2022/1232

Address: 98 Darfield Road, Cudworth, Barnsley, S72 8HG

Description: Convert shop area into a 4-bed dwelling

98 Darfield Road Shop to Residential - Floor Plans
 4-Bedroom Semi-Detached House
 Scale = 1:100

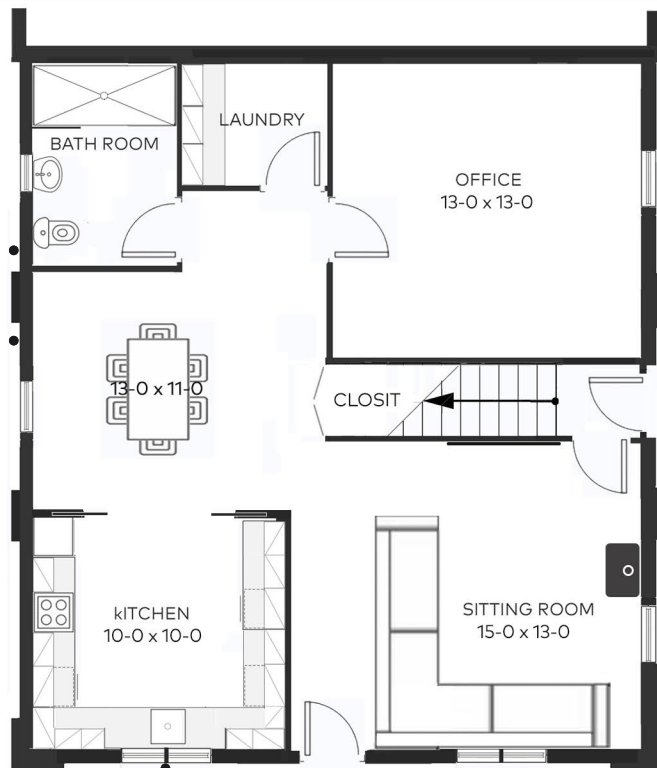
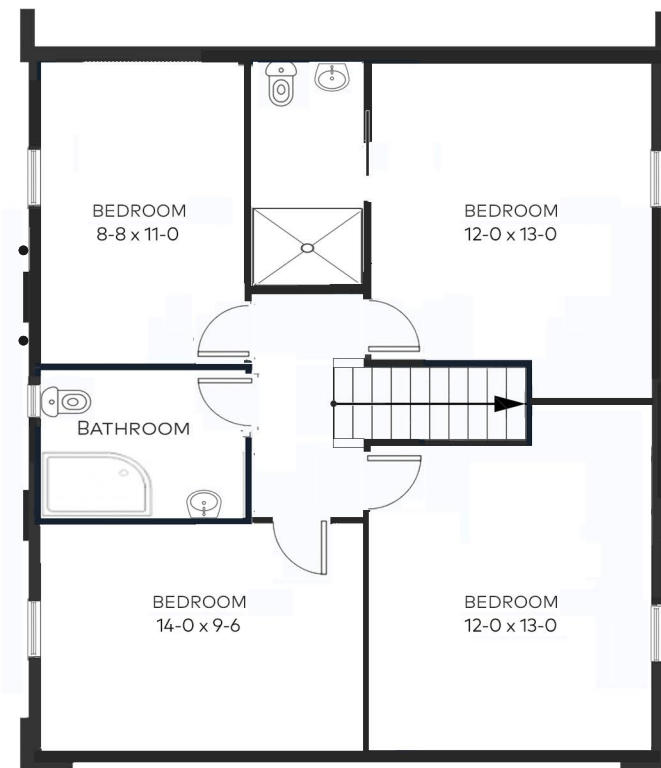
In terms of amenity of future occupiers, the South Yorkshire Residential Design Guide states that a 4-bedroom dwelling should have an overall floor area of 93sqm. At 146.8sqm, the dwelling over exceeds this standard. The proposed bedrooms meet the space standards, however it is noted the proposed kitchen and sitting room are slightly below the standards in the SYRDG. This small shortfall is not considered to be reasonable ground to refuse the proposal considering the dwelling over exceeds on overall amenity and would also have a separate dining room and office space at ground floor.

In terms of light, all habitable rooms of the dwelling are served by a window, with the sitting room being dual aspect to allow for the maximum amount of light and cross ventilation. In terms of outlook the habitable room windows would look onto garden to the south-eastern elevation and a

98 Darfield Road Shop to Residential - Site Parking
and Drainage
4-Bedroom Semi-Detached House
Scale = 1:200

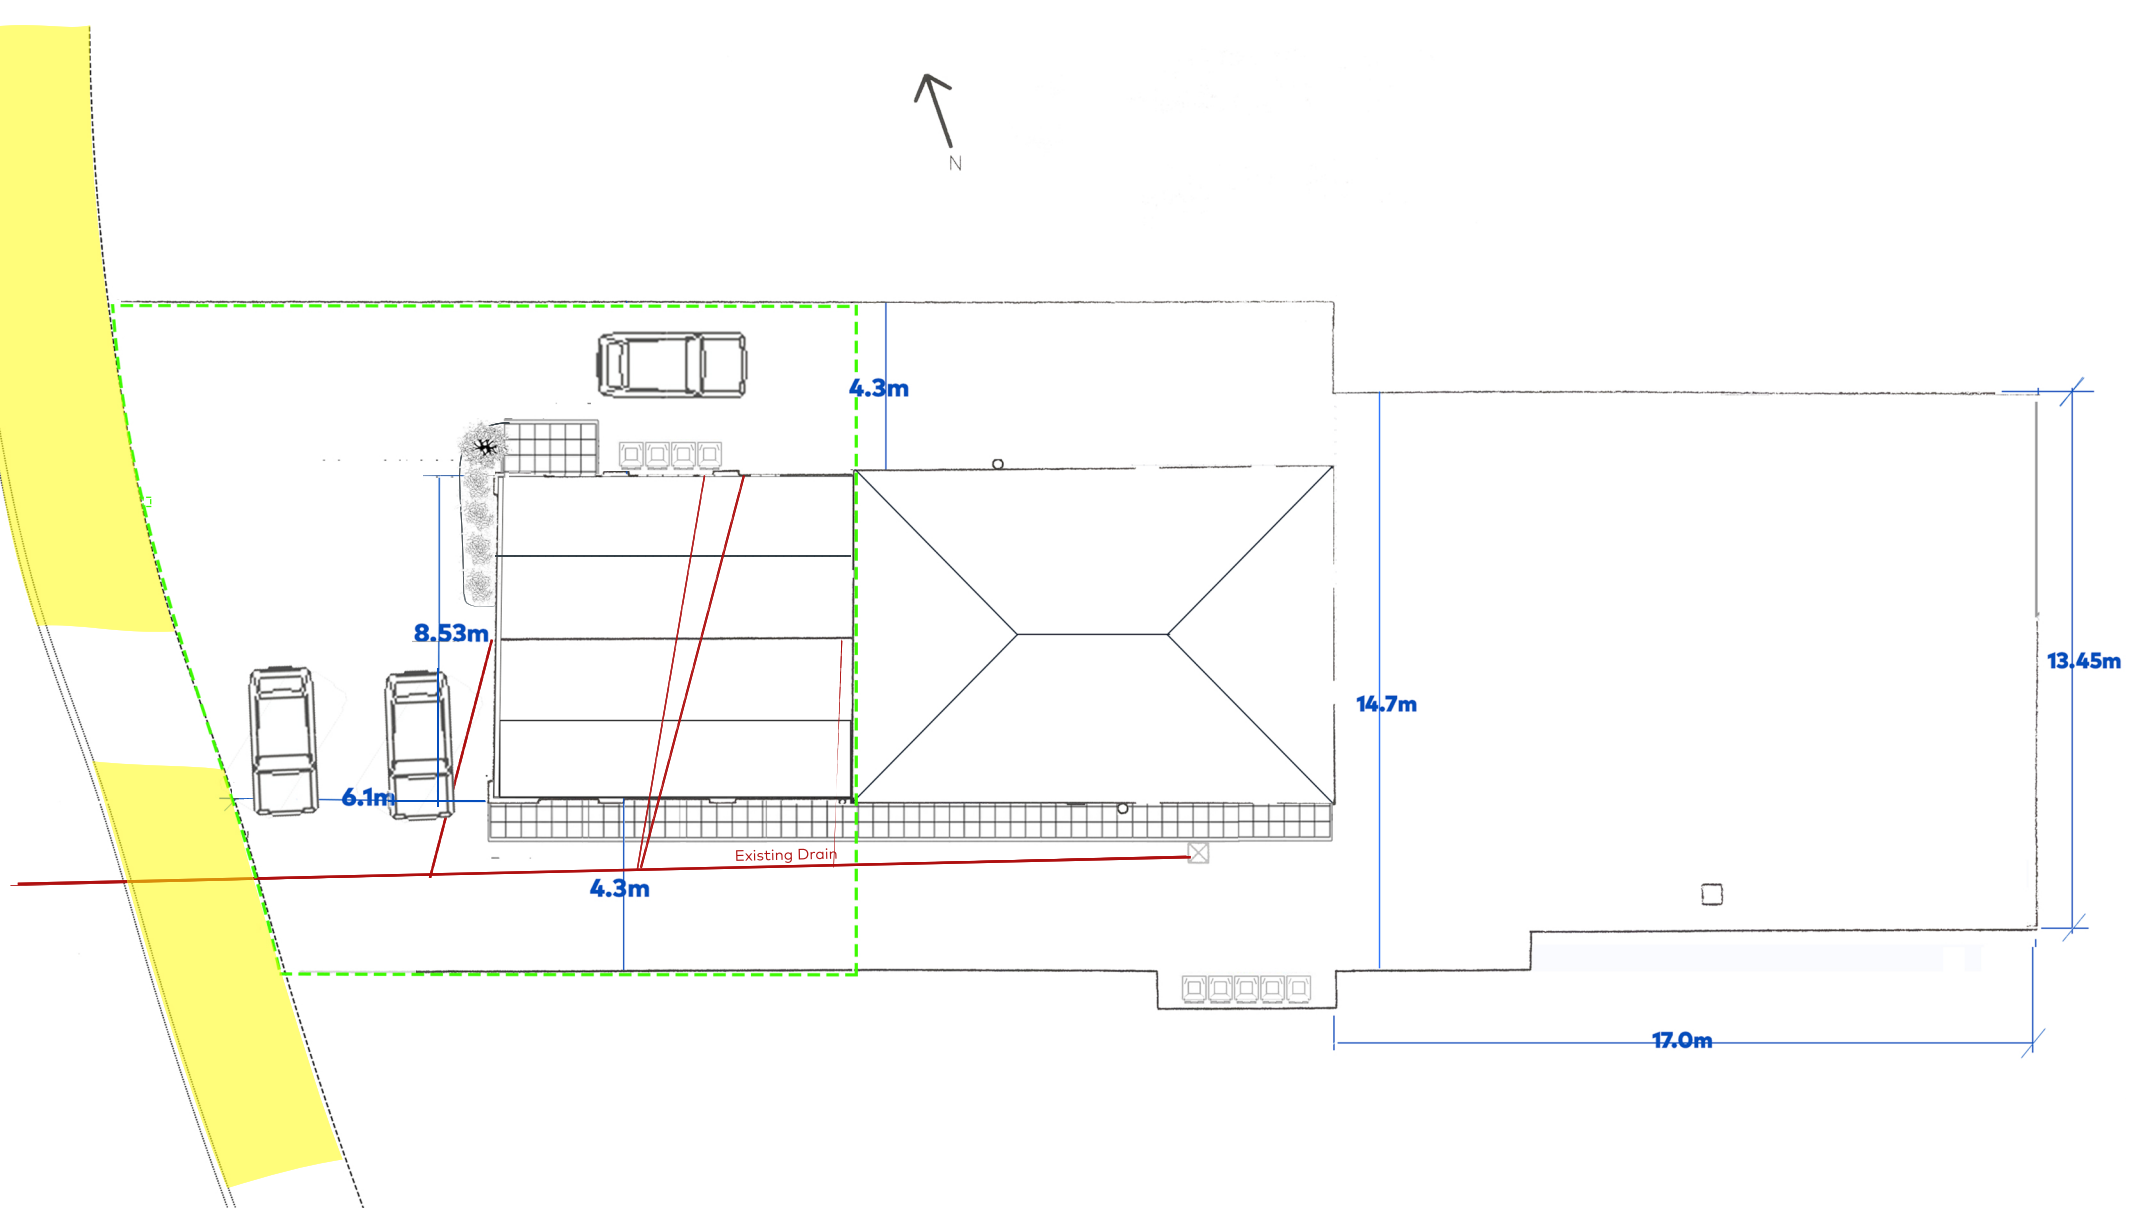
Regarding private amenity space, the SYRDG and Designing New Housing Development SPD states that a 4-bedroom dwelling should have private amenity space of 60sqm. The application does not show any private amenity space. The SPD states that full compliance with standards is expected in predominantly residential areas whereas they may be slightly relaxed in town centre situations/higher density areas. This is dependent on whether there is adequate outdoor green space nearby such as parks. No such justification has been brought forward by the applicant regarding this and the site is not located within the Town Centre or any of the District Centres to be able to offer a relaxation of the standards. Therefore, the development does not comply with the Council's SPD for Designing New Housing Development or the SYRDG.

An approval of the proposed development would set an unwanted precedent for further inappropriate development in the area. The proposed development is therefore contrary to the Council's SPD for New Housing Development in that it does not provide sufficient private amenity space for the dwelling.

Barnsley MBC's Parking SPD recommends two off-street parking places for this size of dwelling. The submitted drawings show ample space for at least three vehicles as well as a bin storage facility. The scheme is acceptable from the perspective of highways, subject to a condition regarding the surfacing of ground for parking spaces.
